CITY OF ALBUQUERQUE

Re: Shell Building & New Restaurant
616 Lomas Blvd. NW
Traffic Circulation Layout
Architect's Stamp 7-25-17 (J14D183)

Based upon the information provided in your submittal received 8-9-17, the above referenced plan cannot be approved for Building Permit until the following comments are addressed:

SHEET NO:
A1.1

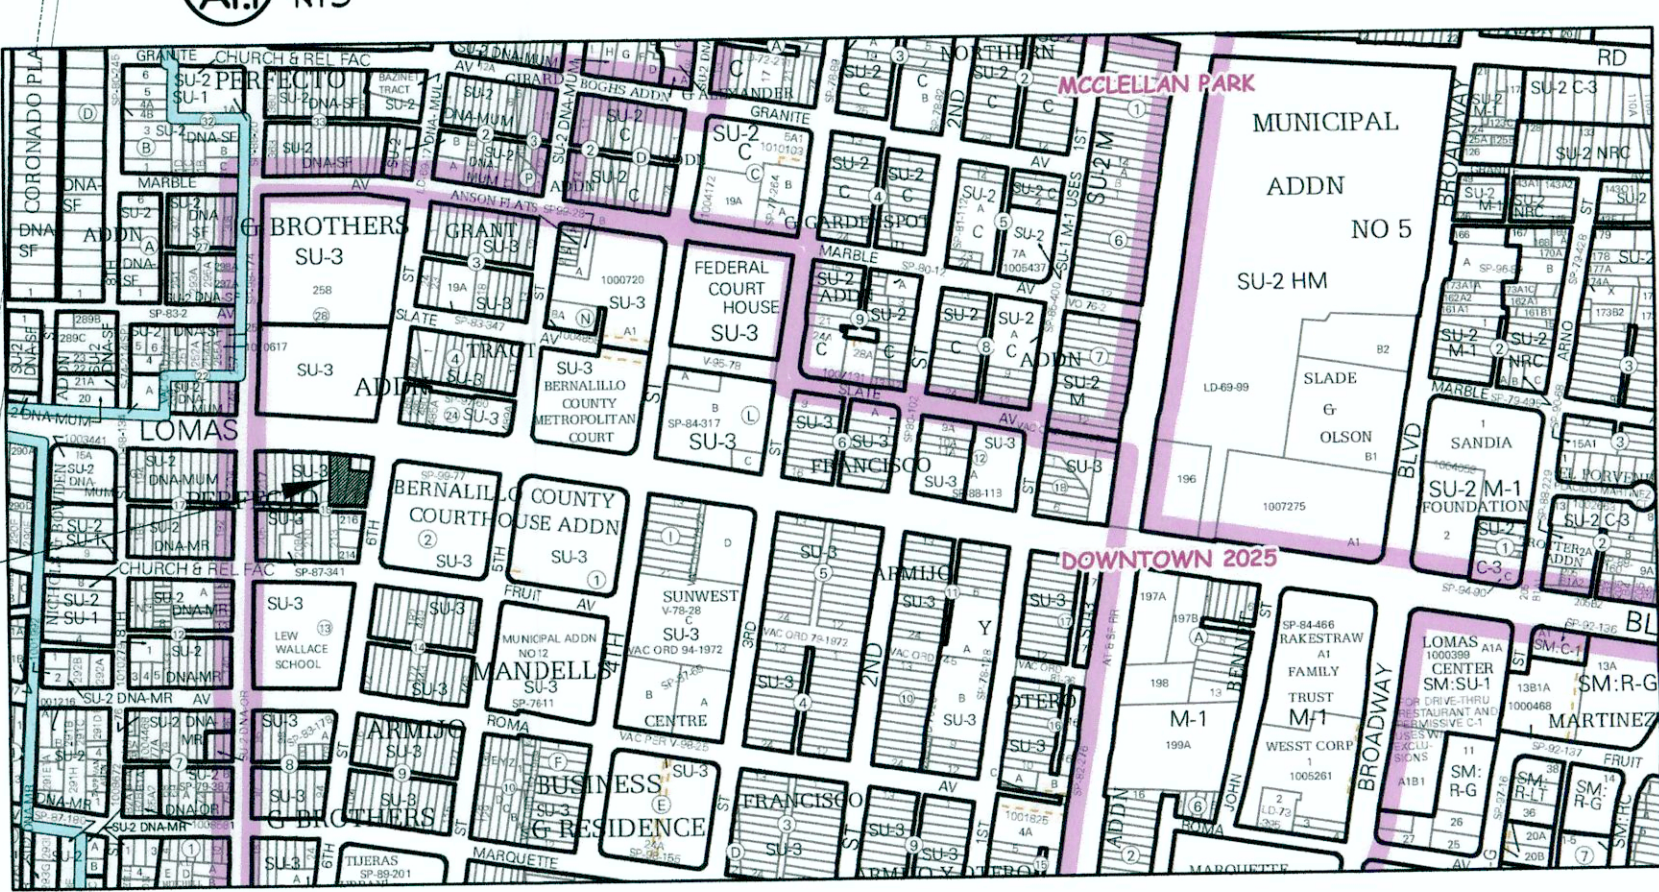
1. List the number of parking spaces required by the zoning code as well as the proposed number of parking spaces including bicycle and motorcycle parking.
2. Please show the two foot overhang will work for the parking spaces that are 16 feet in length. Some may need to be compact.
3. Please provide refuse approval for trash collection.
4. Monument sign must be maintained on site or have a revocable permit/encroachment agreement.
5. Coordinate with traffic engineering to relocate school crossing light @ 505-768-3830.
